CITY OF ALBUQUERQUE

Re: Sawmill Crossing, Grading and Drainage Plan
Engineer's Stamp dated 3-29-12 (H13/D057)

TITLE: *SAWMILL CROSSING - UNIT 2  
REVISED GRADING & DRAINAGE PLAN*

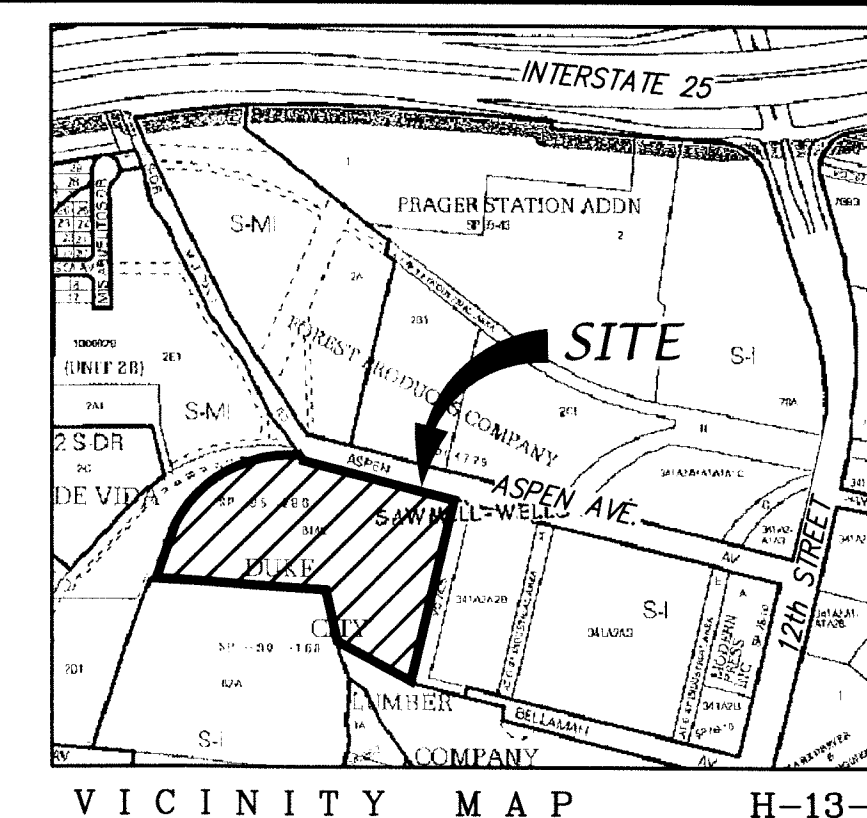
- Due to the flatness of the site and the unique drainage scheme, Hydrology initially thought the amount of imperviousness should be 50% or less. However, a centralized pond as shown on the plan could work if the water in the pond can infiltrate into the ground. It would be preferable for the water in the pond to infiltrate in 24 hours, so that it will be nearly dry before the next rainfall event.

- It is my understanding that in this location, there is a layer of soil with acceptable percolation rates at 5 or 6 feet below the ground surface. The proposed pond is 6.3 feet deep and therefore the pond bottom may be in this soil with acceptable percolation rates. Provide a bore log in the location of the proposed pond and percolation calculations to aid in the determination of the time it will take for water in the pond to infiltrate.

- Since this site will be developed in phases, provide a grading plan that shows the lots to be developed as well as grades on the undeveloped areas. If you prefer, comments on the grading plan for future phases can be addressed when those phases are developed.

- Do you intend to grade the entire site creating pads for Unit 1 and rough grading for the other areas or creating pads and street grades on the entire site?

- Provide the Volume Required, Volume Provided and WSE for the proposed pond on the grading plan.
- Provide a spillway for the pond and show the inlet on the site to the south that will receive the runoff. The spillway can be rock, but not small rock.

- The pond walls should be constructed of continuously poured concrete not CMU blocks. Details to be determined at DRC.
- Is there supposed to be an inlet in each cul-de-sac? Show the storm drain.

- Provide existing elevation data on the east and west sides of the site. Additional survey data should be provided to determine if the existing concrete runoff between lots 42 and 41 drains to the east. During a site visit, it appeared that flows don't drain to the east as witnessed by an area of fines on this site.

- Show the built environment on the Sawmill site to the south in the area of the proposed pond.
- It appears the 5'x5' landscape areas may drain out the back rather than out to the front per the drainage report.

- Aspen Ave currently drains west to east across the frontage of this site. You are proposing to introduce a high point in Aspen Ave near lot 23 that will interrupt the existing flow pattern.

- Provide a water block at the entrance to this site.
- Provide slopes and flows for all channels.
- The channel that daylights near lot 58 has an invert of 61.70. The downstream (?) grade on the other side of the sidewalk is proposed to be 62.31. Should the sidewalk culvert extend across the sidewalk?

- To help minimize the amount of imperviousness, single car width or narrower driveways should be considered.
- Retaining walls are shown near lots 73, 58 and 51. They appear to be unnecessary due to the flatness of this site.

- Please provide street names on the grading plan.
- Provide flow arrows in the back yards of Lots 1 through 7.
- The plan proposes curb and gutter and sidewalk across the railroad tracks. How will this be built? Provide spot elevation data at regular intervals in the location of the railroad tracks.
